Environment, Inc.

TRAFFIC IMPACT STUDY RESPONSE
(Staff Report of 2--2023)
~~Schubert Ranch Sand Resource Pit~~
PPR 234
Revised 4-19-2023

BAGGETT ROAD ACCESS DRIVEWAY PLAN
SCALE 1"=30'

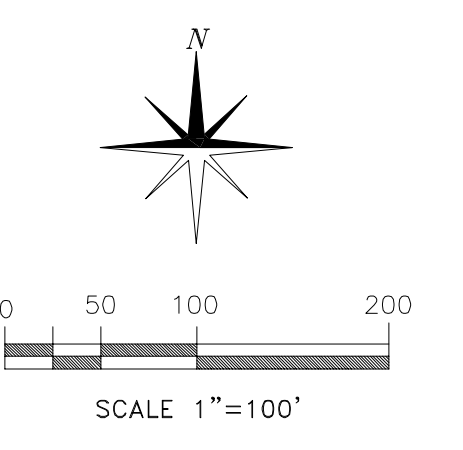
Additionally, it was identified in the previous special use application traffic study that an Autoturn analysis along with recommendations would be provided at this site development stage for the driveway access onto the County roadway. Please update the TIS to provide the necessary recommendations.

Please identify in your letter of intent that this Sanborn access shall not be utilized for the mining operation. Additionally, in the letter of intent identify that this is a ranch access (per site plan) and identify the design vehicle that will utilize this access (passenger car/pickup, single unit truck, multi-unit). The vehicle and use will determine the required access spacing from the existing driveway to the west per ECM table 2-35. A deviation request will be required for this access as it is currently approx. 330' from the existing access to the west.

new access from the private gravel road to Baggett Road, also gravel, will have a minimum turning radius of 4 trucks.
